KITTITAS COUNTY

DEPARTMENT OF PUBLIC WORKS

DATE: October 29, 2008

SUBJECT: Amabilis View Estates Short Plat SP-08-42

**K.C.S.P. NO. 08-00042**

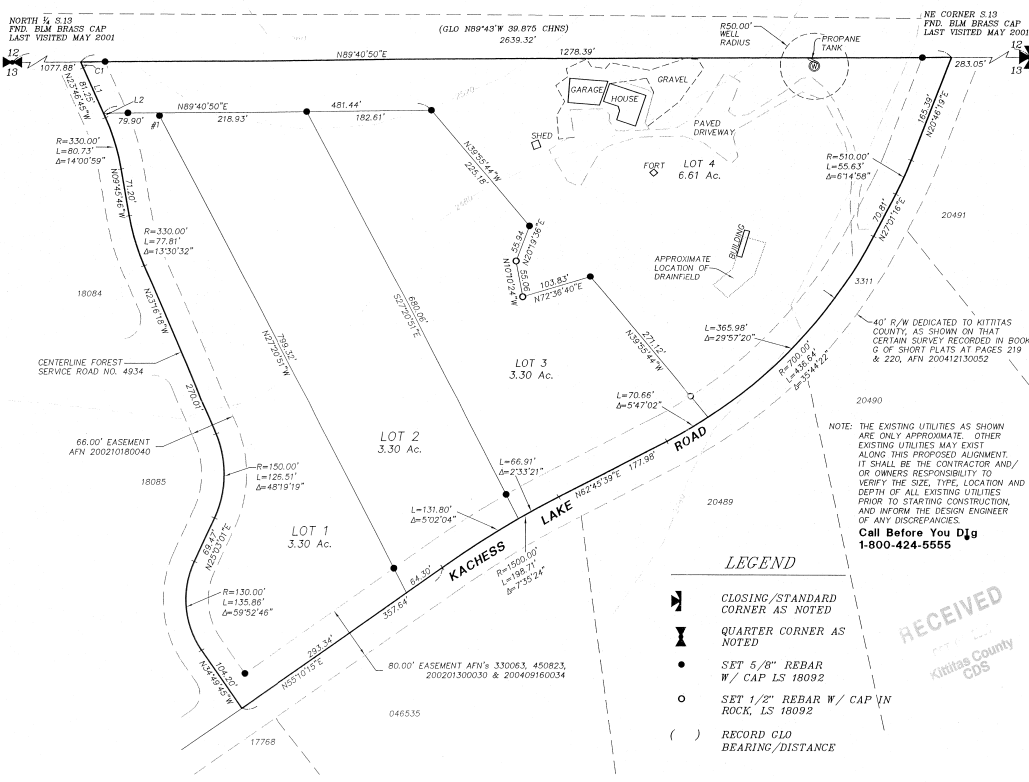
1. County Road Right-of-Way: 40' shall be dedicated to Kittitas County for the Kachess Lake Road right-of-way.
2. Dedication: The following dedication shall be shown on the final plat:

3. Access: Kachess Lake Road is classified as a Rural Minor Collector with a speed limit of 35mph. Accesses must meet the 150' spacing requirement. Joint-use accesses may be required.
4. FS Road 4934: No access from FS Road 4934 will be allowed without approval from the US Forest Service.

- Any further subdivision or lots to be served by proposed access may result in further access requirements.
6. Plat Notes: The second sentence of plat note number 6 shall read "See Kittitas County Road Standards."
